SAFETY AUDIT

STAGE 1/2

Wadsworth Gardens PROWs, Cleckheaton

**ON BEHALF OF
BARRATT & DAVID WILSON HOMES**

TITLE: **S38 PHASE 2 PROPOSED SURFACE FINISHES & KERBING SHEET 1 OF 2**

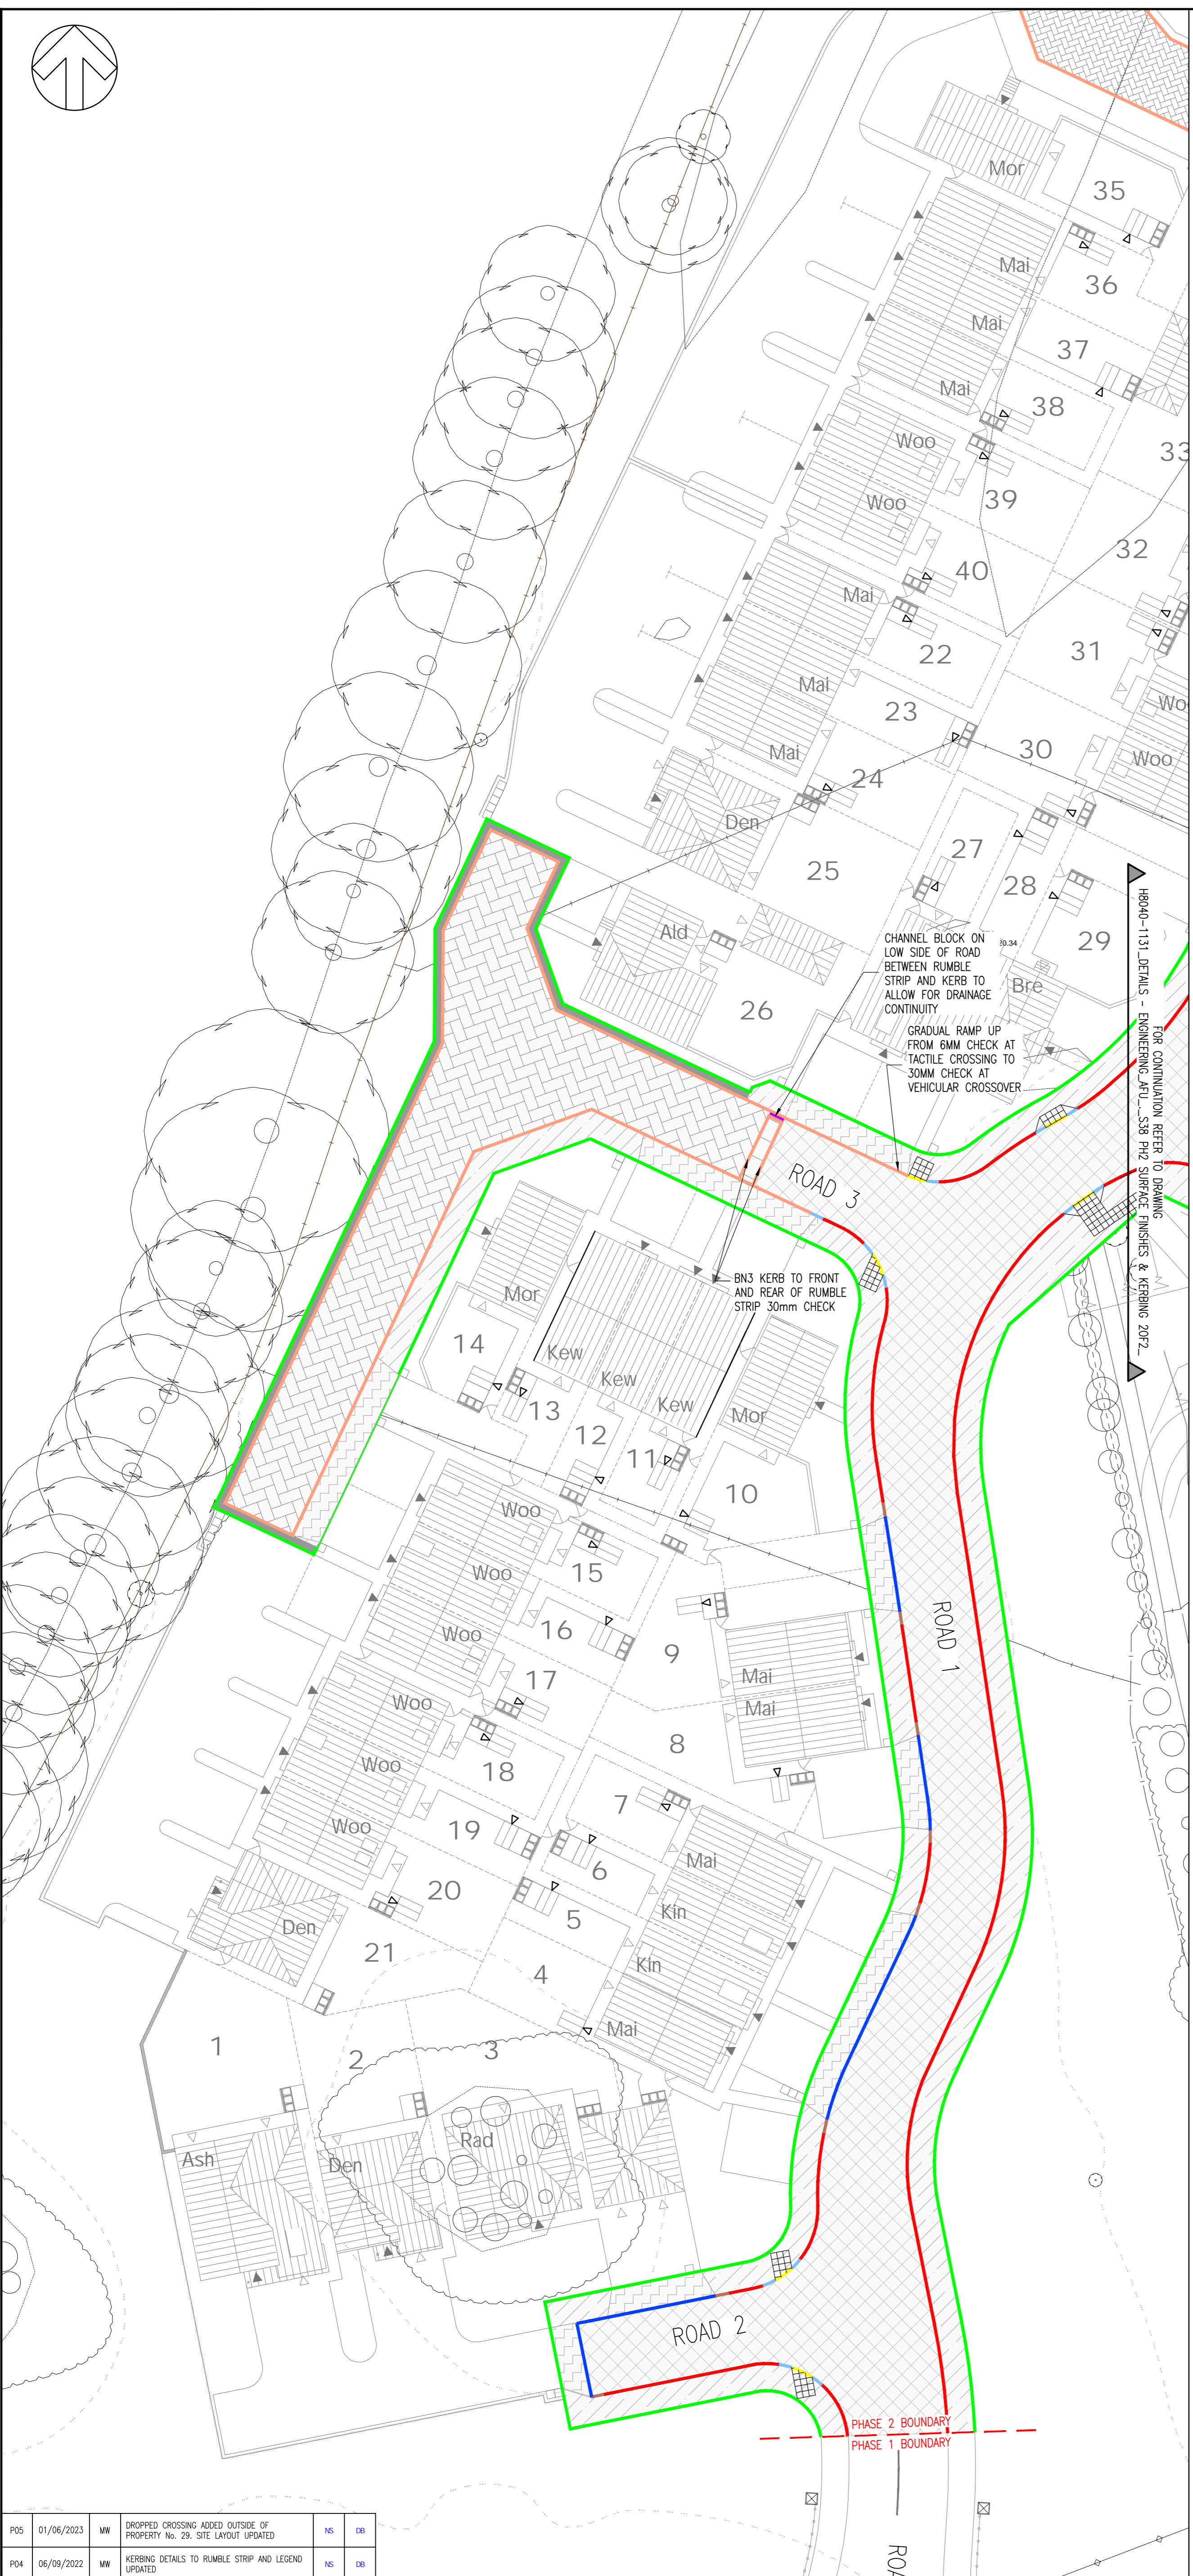
Summary: *The proposals indicate that part of the diverted PROW will cross Road 1 in the vicinity of plot 111. This uses the vehicle crossover to the drive to plot 111 and there is no dropped kerb or tactile paving on the opposite footway. Failure to indicate a safe crossing point for pedestrians could lead them to use less safe locations.*

The drawings indicate that part of the diverted PROW will cross Road 1 in the vicinity of plot 111 using the vehicle crossover to its driveway. The Audit Team has noted that there is no dropped kerb or tactile paving on the opposite footway in this location.

Whilst the potential for a crossing pedestrian being in conflict with a vehicle using the driveway to plot 111 is small, the location is not ideal and would make it difficult to provide tactile paving in that location. The lack of a dropped crossing and tactile paving on the opposite footway would result in people in wheelchairs or with perambulators having to bump over full height kerbing.

It is recommended that the design team review the location of this crossing point and place it away from driveways so as to allow the provision of dropped crossings and tactile paving.

TITLE: RETAINING WALL SECTIONS

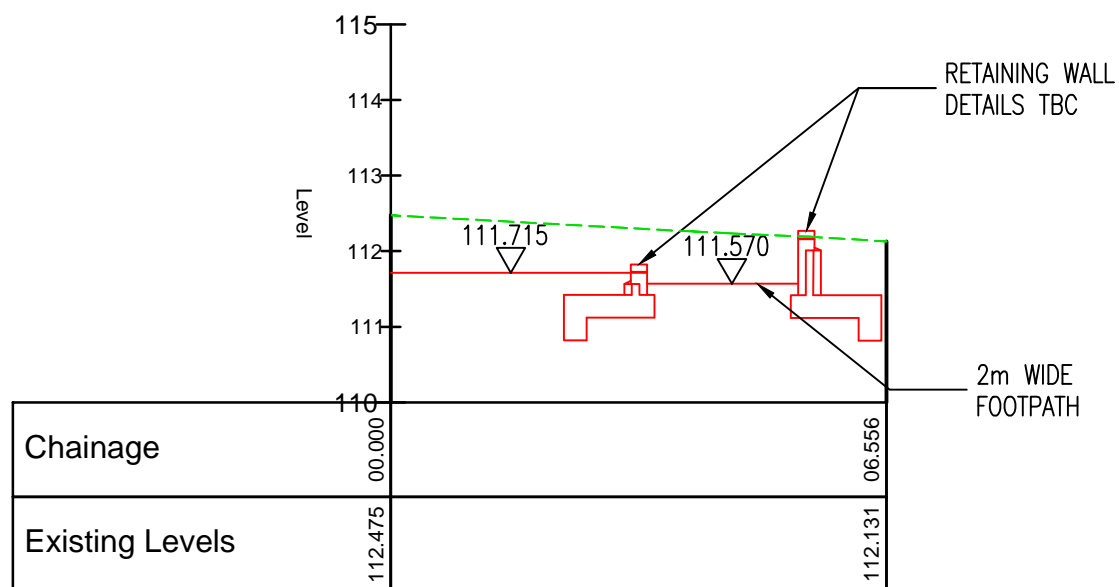
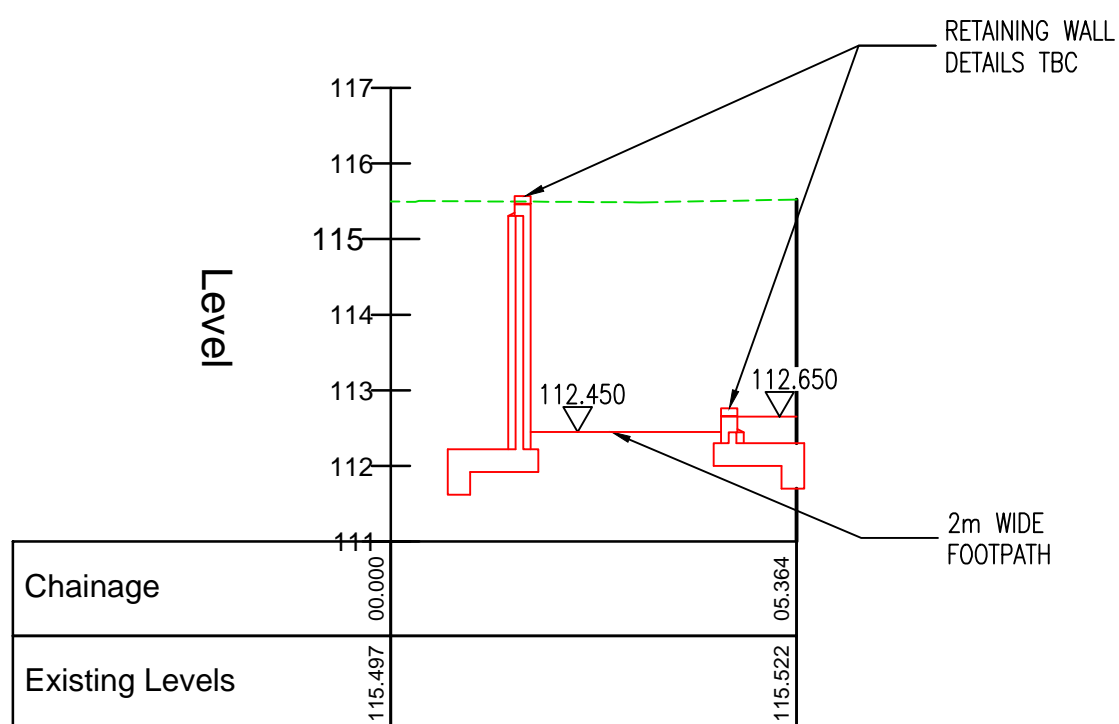
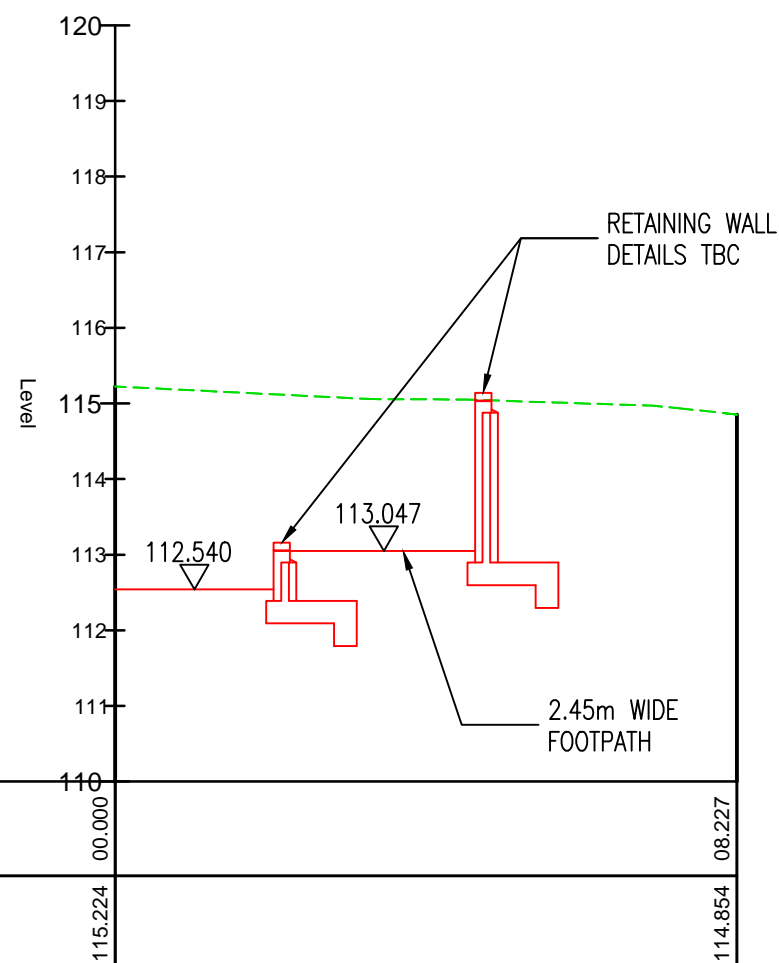
The design of the proposed ramp has gradients of 1 in 15 between platforms of 1.2m in length and will be 2m wide. The proposed alignment will place users some 1.8 – 2.0m above the proposed levels of the adjacent highway on a sharp bend in the ramp with no indication to people with vision deficiencies of a safe edge / boundary to follow or provision of hand rails or edge restraints / boundary treatments.

The proposed landings also appear to be quite short particularly for those in wheelchairs or pushing perambulators.

It is recommended that the ramp design be reviewed against current good practice guidance and drawings be amended to provide people with vision deficiencies guidance in its use and route and protection from the level difference and adequate landing lengths for wheelchair users and those with perambulators.

PEDESTRIAN VERTICAL VISIBILITY SPLAYS BASED ON EYE HEIGHT AT 1.5m LOOKING DOWN/UP OF 0.6-2m

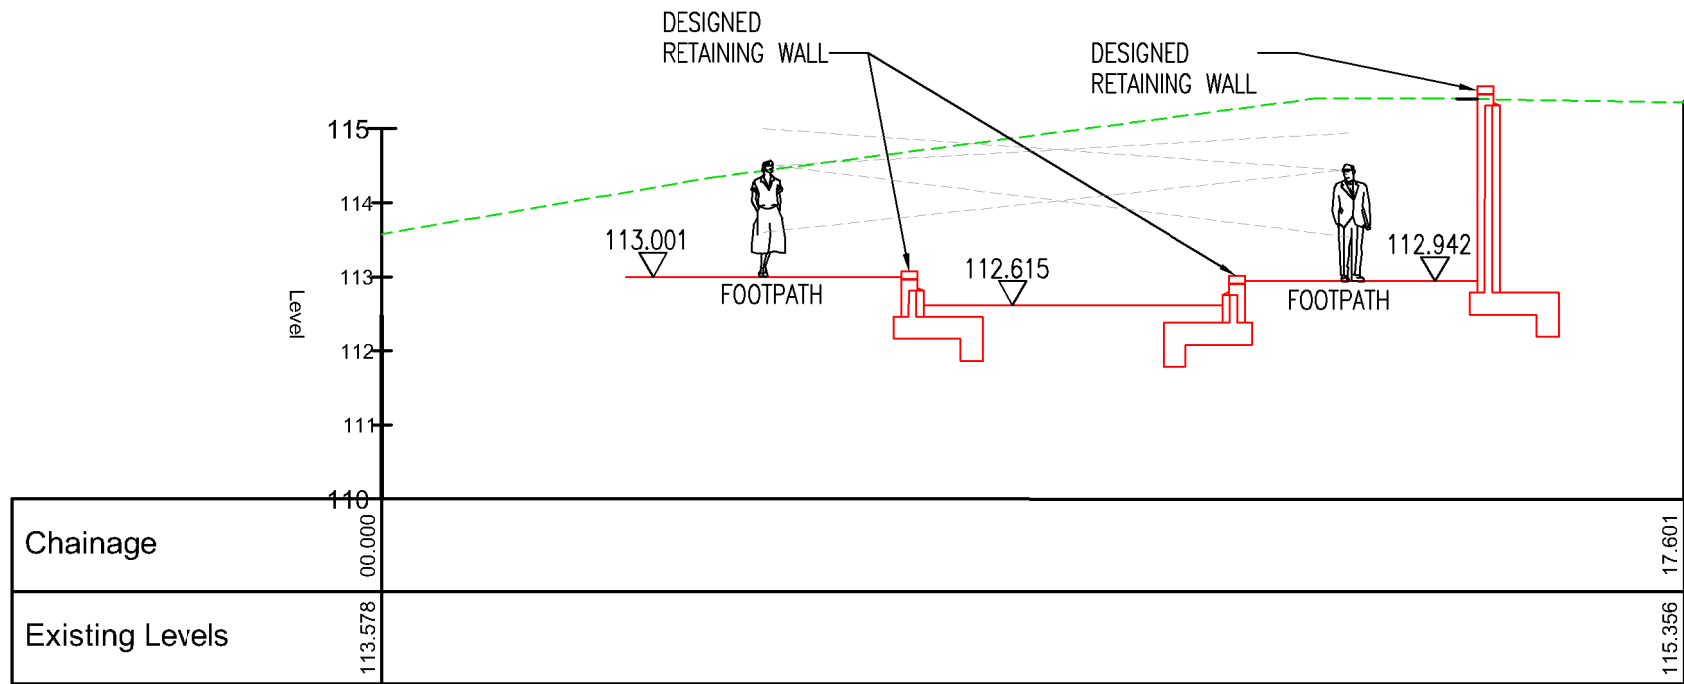
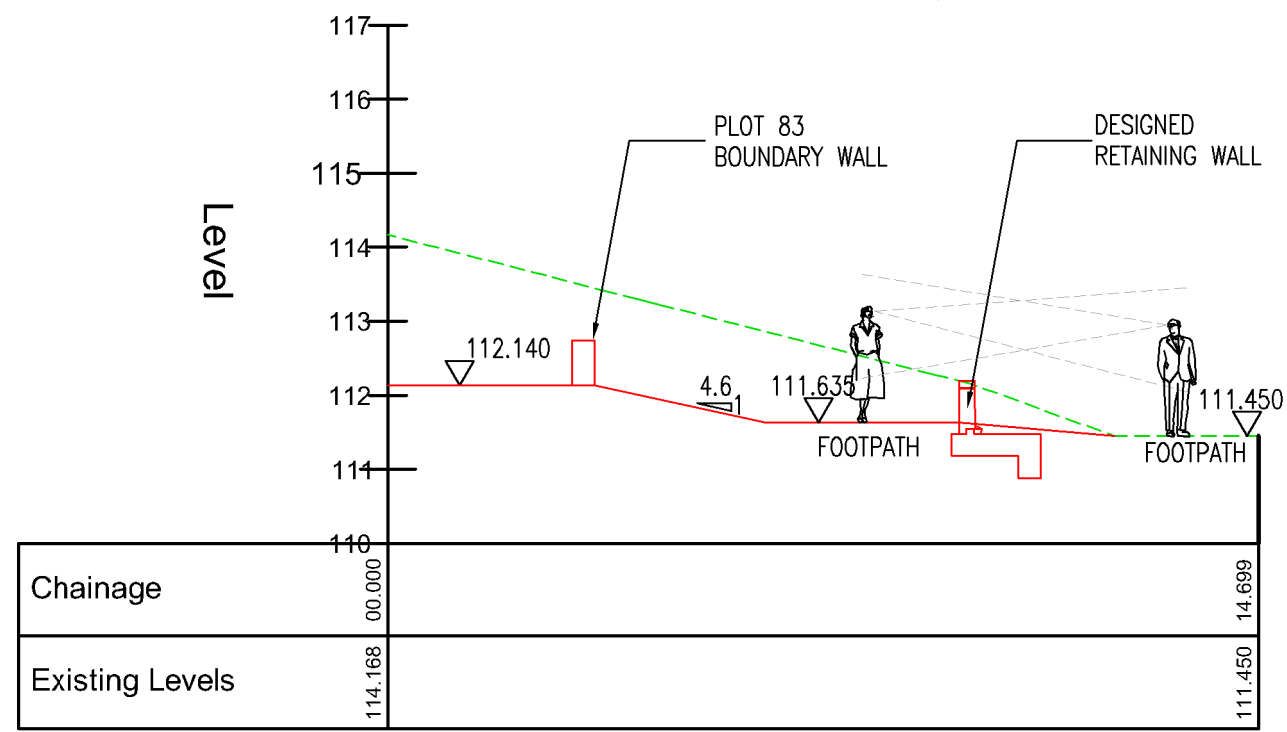
Summary: *No visibility splays shown on the drawings for pedestrians crossing Road 1 adjacent to the bottom of the proposed ramp in the new PROW near plots 28 / 29. It is unclear whether adjacent boundary treatments / retaining wall parapet would obstruct splays placing pedestrians in danger.*

No visibility splays are shown on the drawings for pedestrians using the proposed crossing location for the new PROW adjacent to the bottom of the ramp near plots 28 / 29. Pedestrians crossing from south to north after emerging from the ramp would have to look left over the retaining wall to view oncoming traffic. It is not clear whether the height of this wall relative to the vertical alignment of Road 1 would prevent a pedestrian from observing an approaching vehicle and vice versa.

For pedestrians crossing at the same location but from north to south, it is not clear whether there is sufficient visibility afforded to a pedestrian within the proposed highway of vehicles approaching from the north and vice versa without cutting across into private garden areas where planting might obstruct their view.

It is recommended that the drawings be amended to show that adequate visibility can be achieved at this crossing point for pedestrians and boundaries / treatments be designed so as to avoid them being obstructed.
